**Subject:** RE: Mike Bach BLA

JOB NO.: N/A  
 DATE: 3/16/2022  
 DRAFTED BY: LMR  
 CHECKED BY: MRM  
 SCALE: 1" = 100'  
 2 OF 2

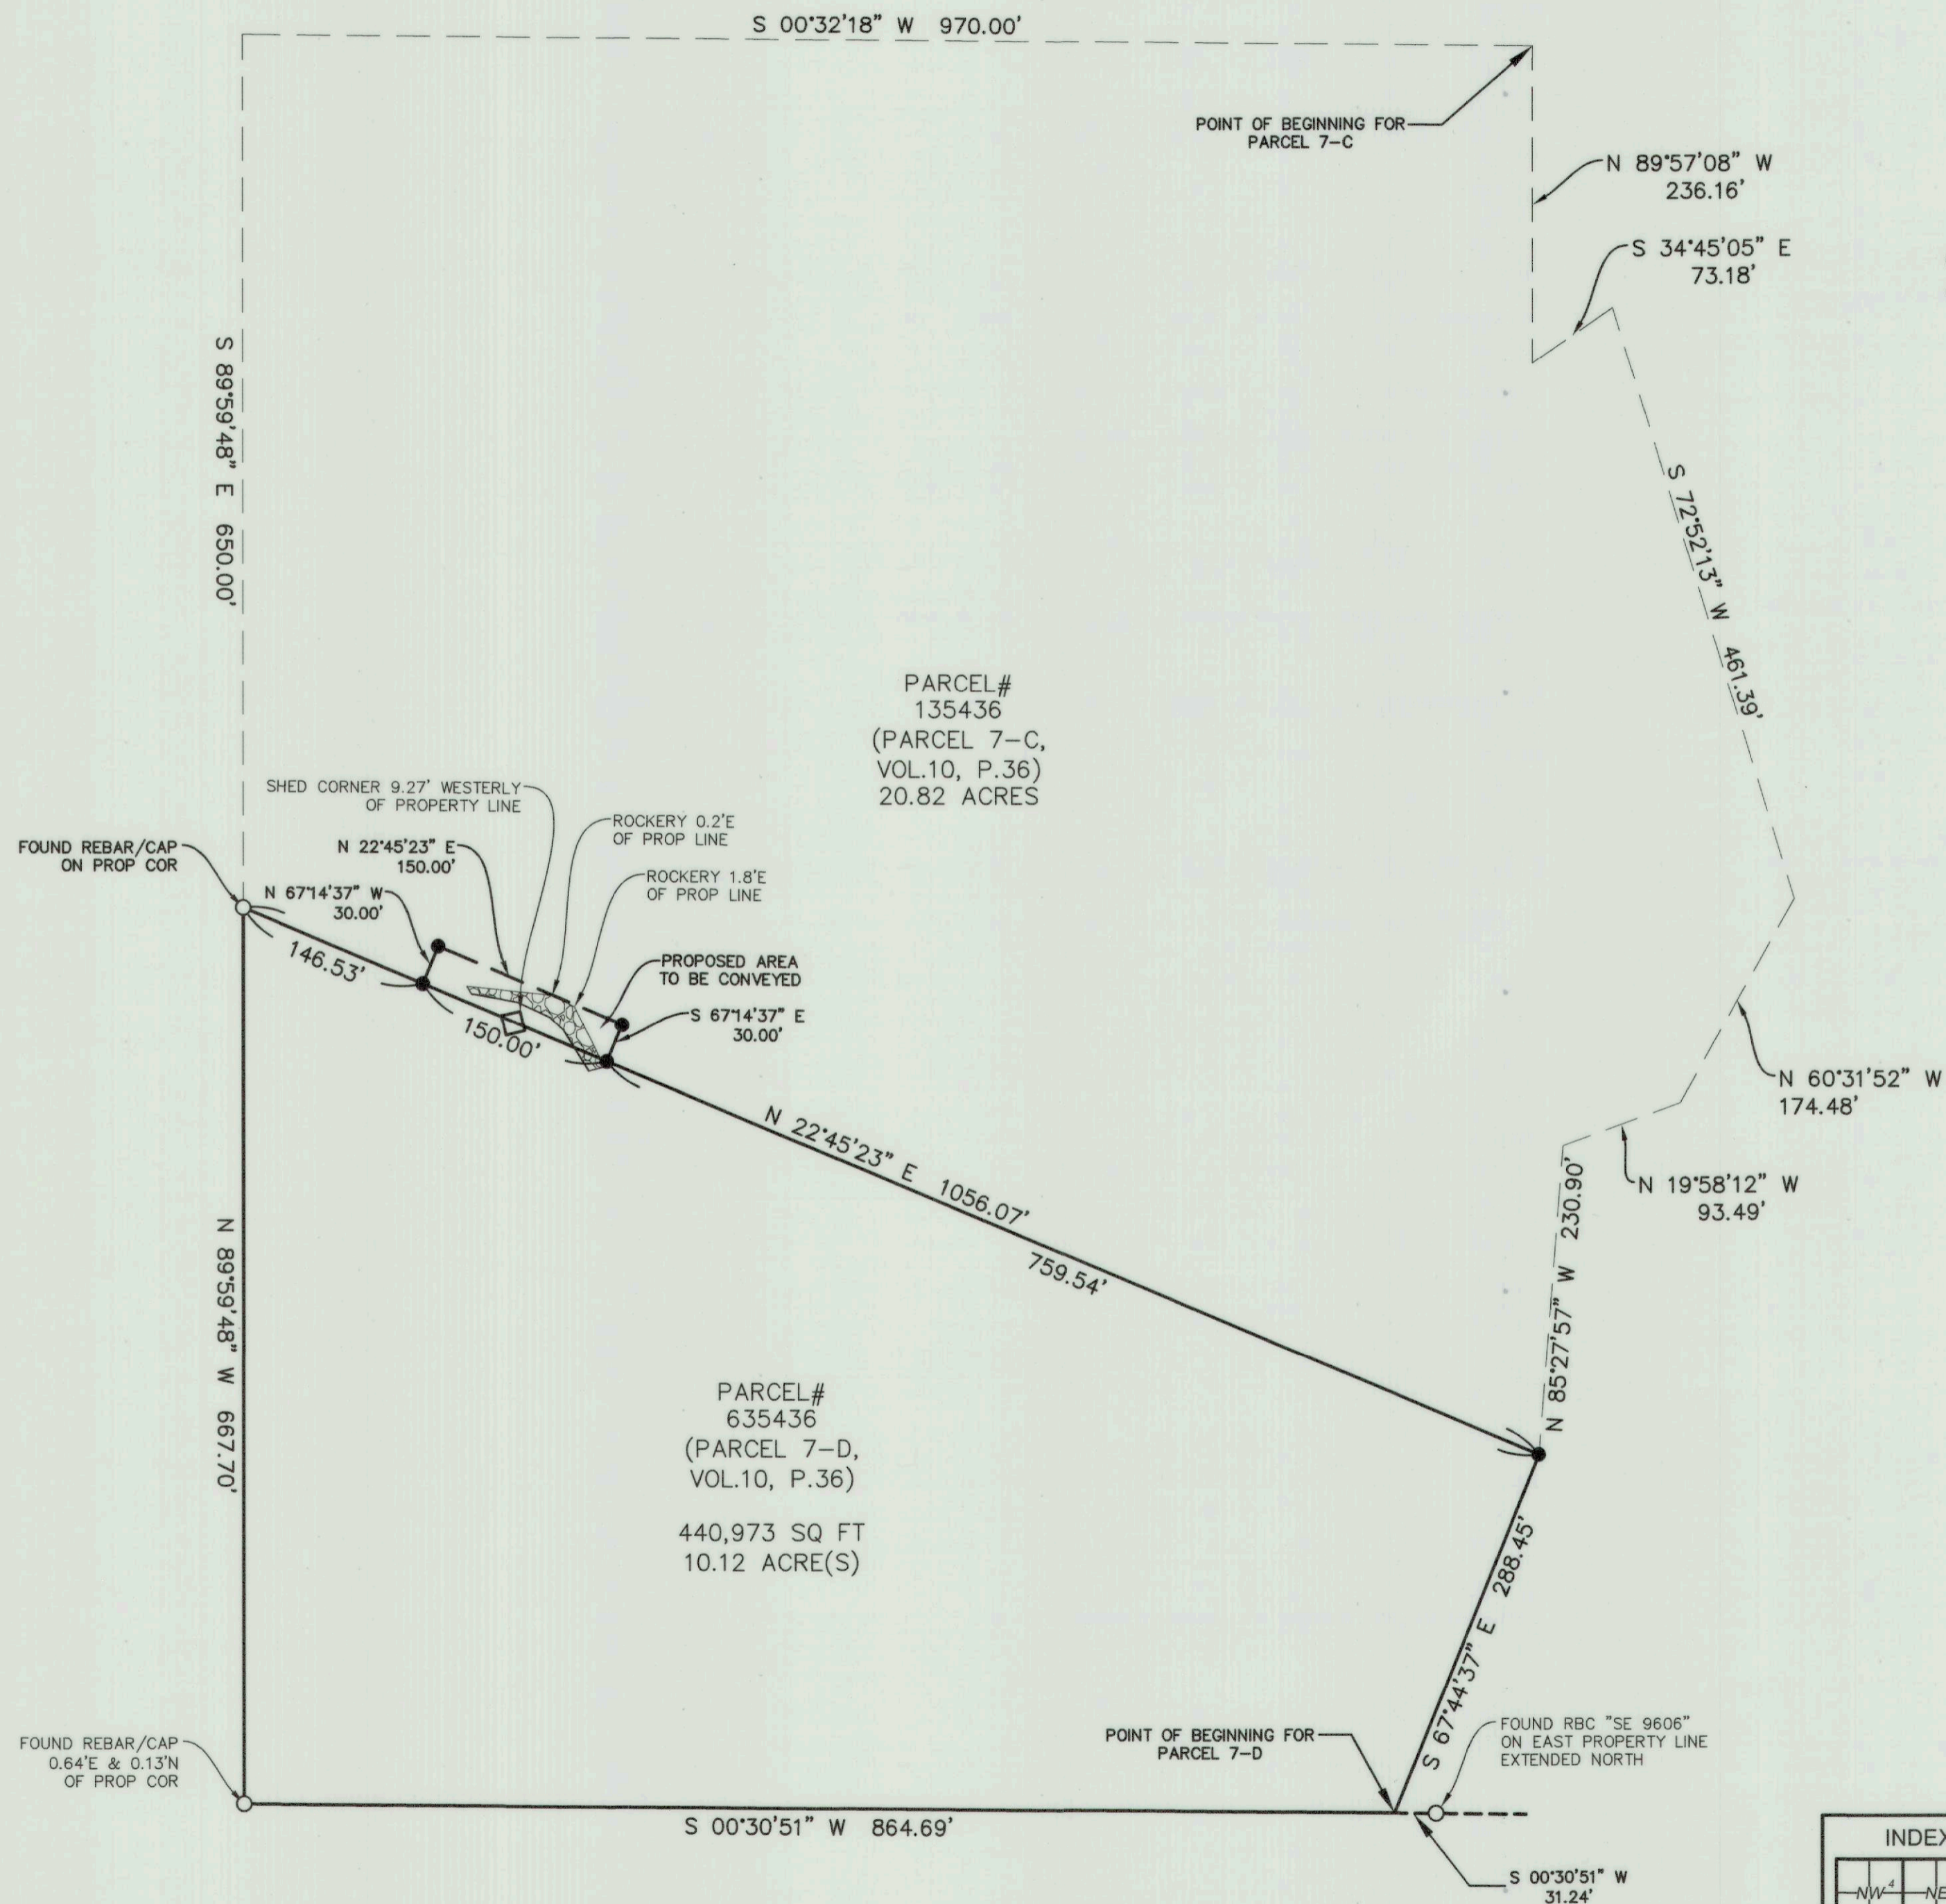
1. The entire new division line shall be staked in the field.  
*Please set property corners for the new division line, and show on the face of your survey.*
2. The proposed survey fails to adequately show controlling survey evidence. Please include ties to controlling corners suitable for sensible retracement of the boundary line adjustment.  
*Of the three corners shown on the face of your survey, one is shown as being off, and one does not show distance ties. Please include enough suitable corners and/or information for subsequent surveyors to retrace your work.*
3. The "Adjoiner" legal description does not match the text of the title report of record.  
*I have included the title report for your use. If there is a reason that the title report is incorrect, insufficient, or ambiguous, the title company can be notified and an updated title*

This submittal has addressed all of my prior comments.

JOB NO.:	N/A
DATE:	12/1/2021
DRAFTED BY:	LMR
CHECKED BY:	MRM
SCALE:	1" = 100'
	2 OF 2

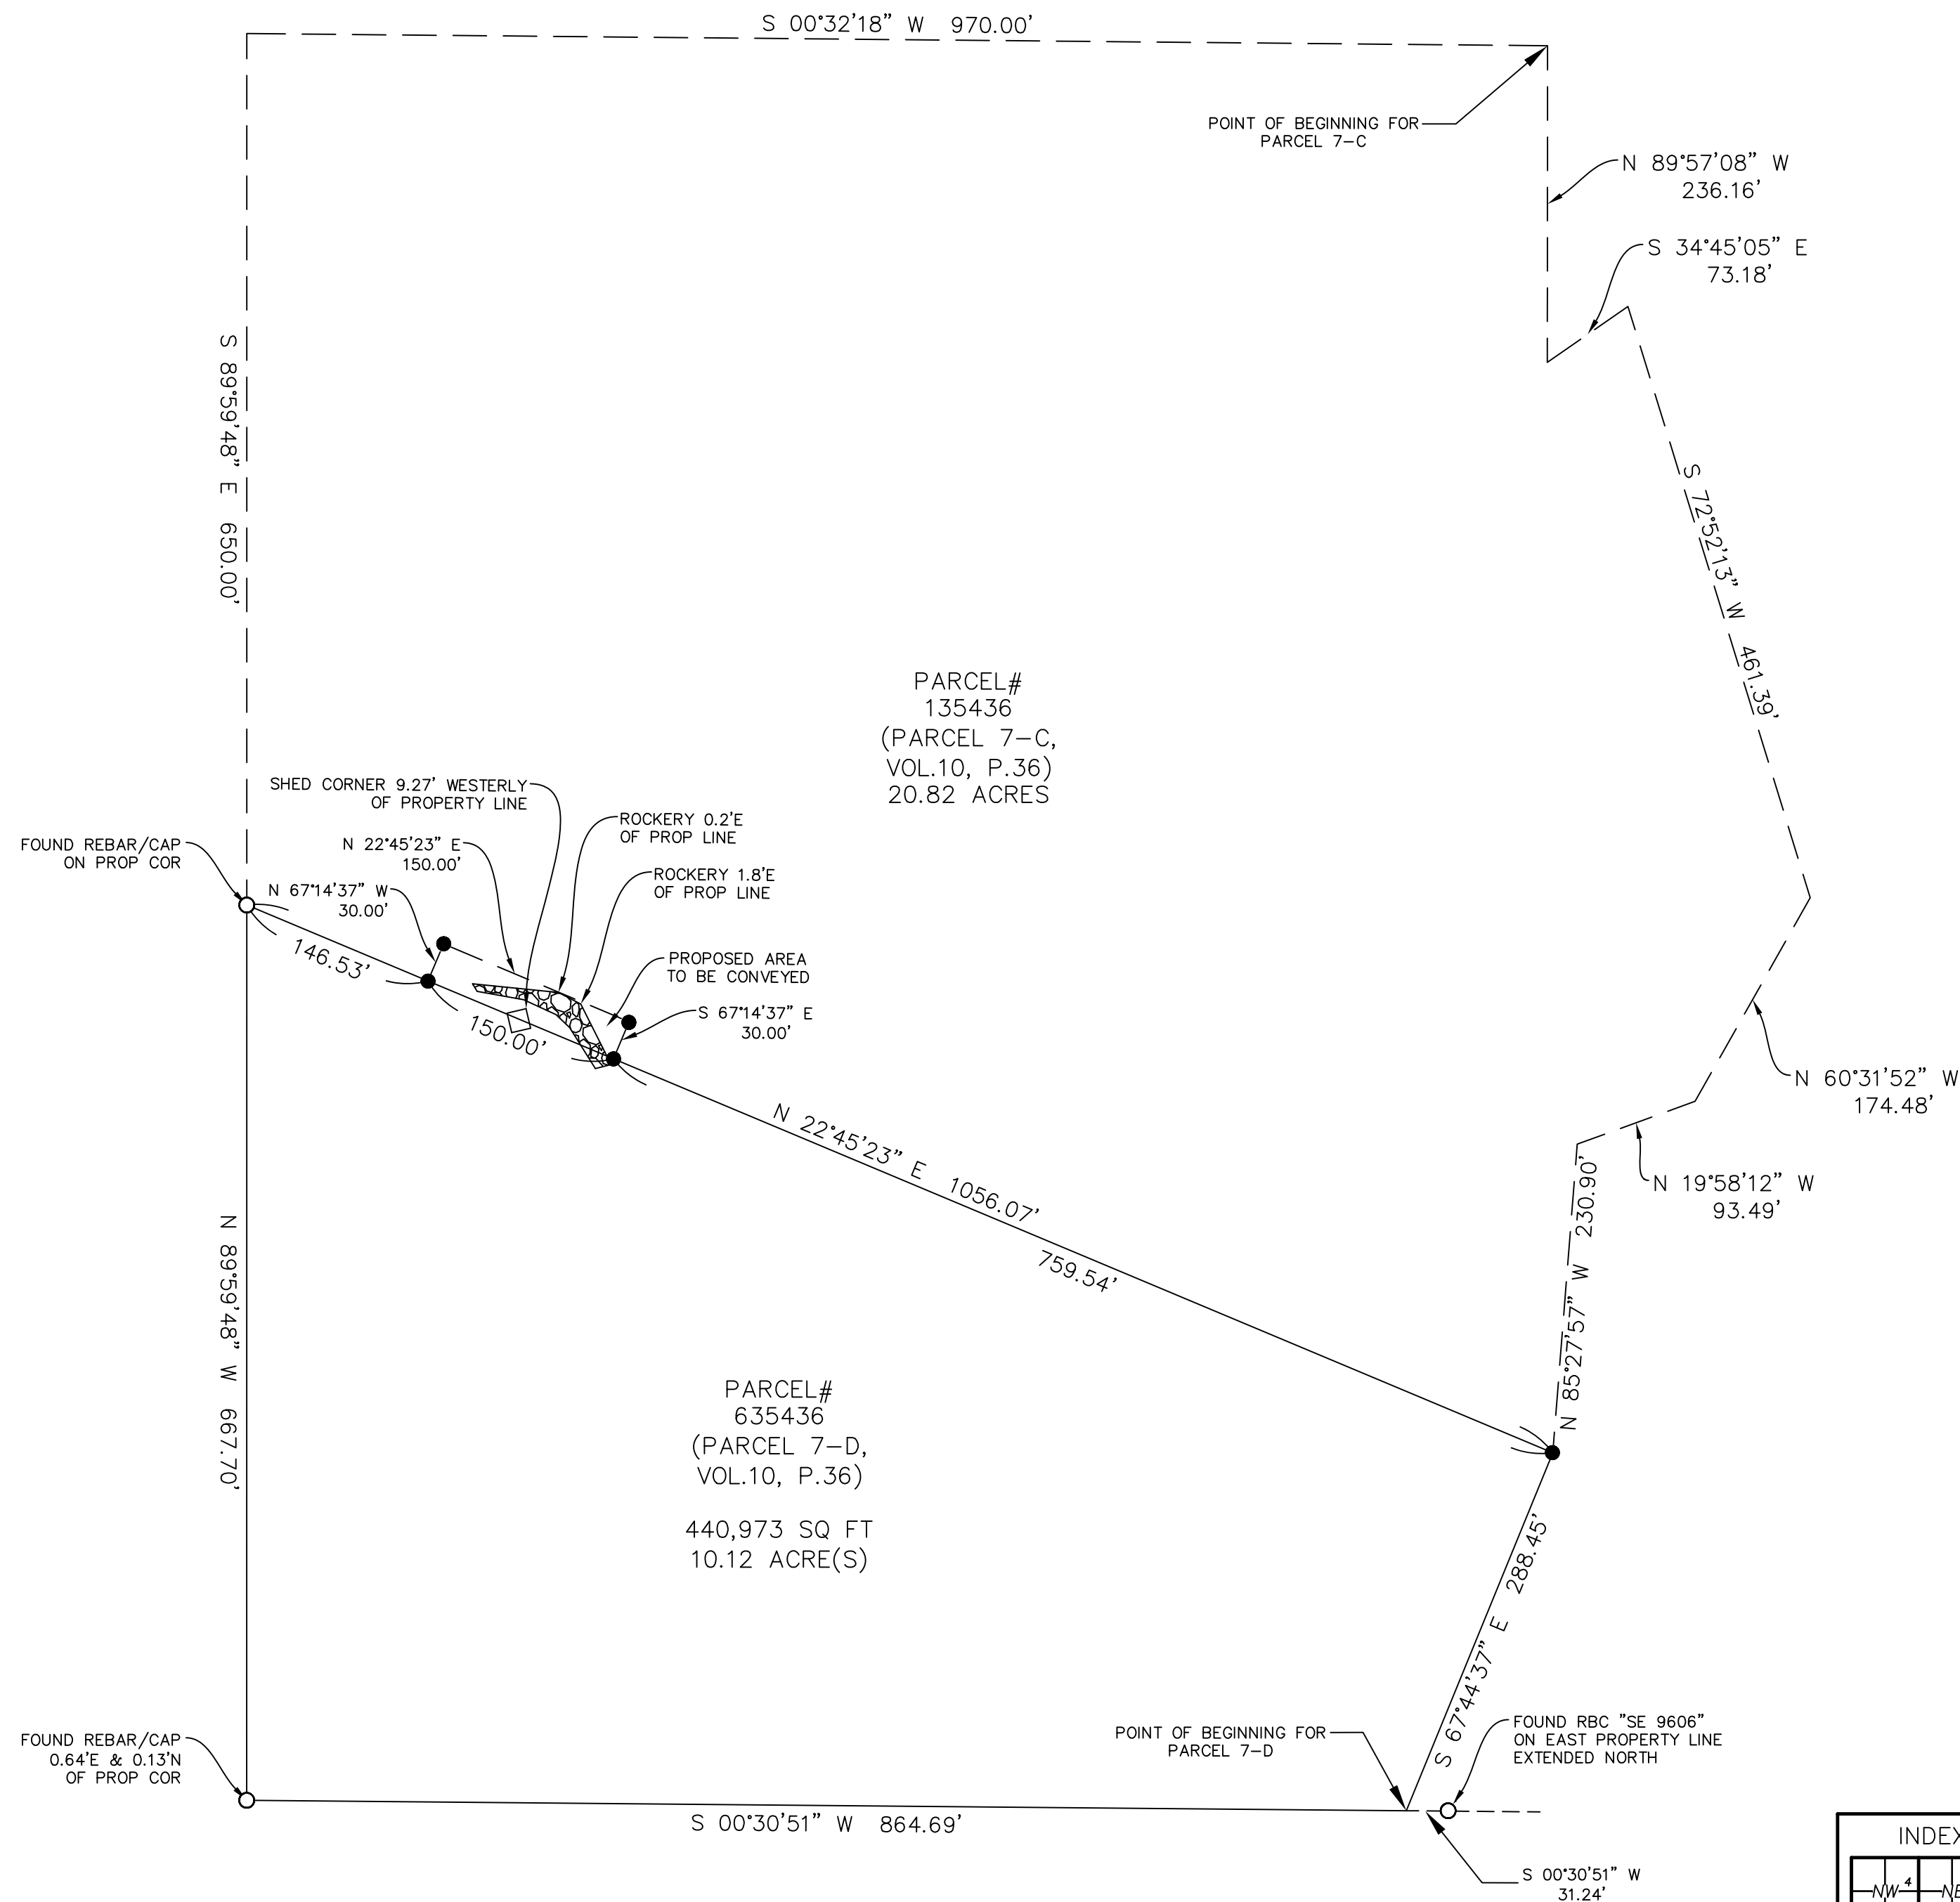
4. The legal descriptions are a mixture of basis of bearings. The original descriptions match the survey of record, while the transfer parcel matches the prepared map. Correcting the basis of bearing issues would resolve this, but alternatively, the record bearings could be provided on the face of the map in brackets "(XXX.XX)" and referenced on the legend.

5. The line "Thence S00°30'51"W, 864.69" within the Bach Legal description is missing from the title report. The title company can be informed, and generate an updated title OR, if they are unwilling to do so, the discrepancy can be noted and the source of the missing data (Survey:10-36) provided.

*This has been addressed on the most recent map dated 12/01/2021. No changes needed.*

*I have included the title report for your use. If there is a reason that the title report is incorrect, insufficient, or ambiguous, the title company can be notified and an updated title report can be prepared and resubmitted. If the title company is unwilling to make corrections, noting your description together with the title report description and why your description was needed would be a suitable option.*
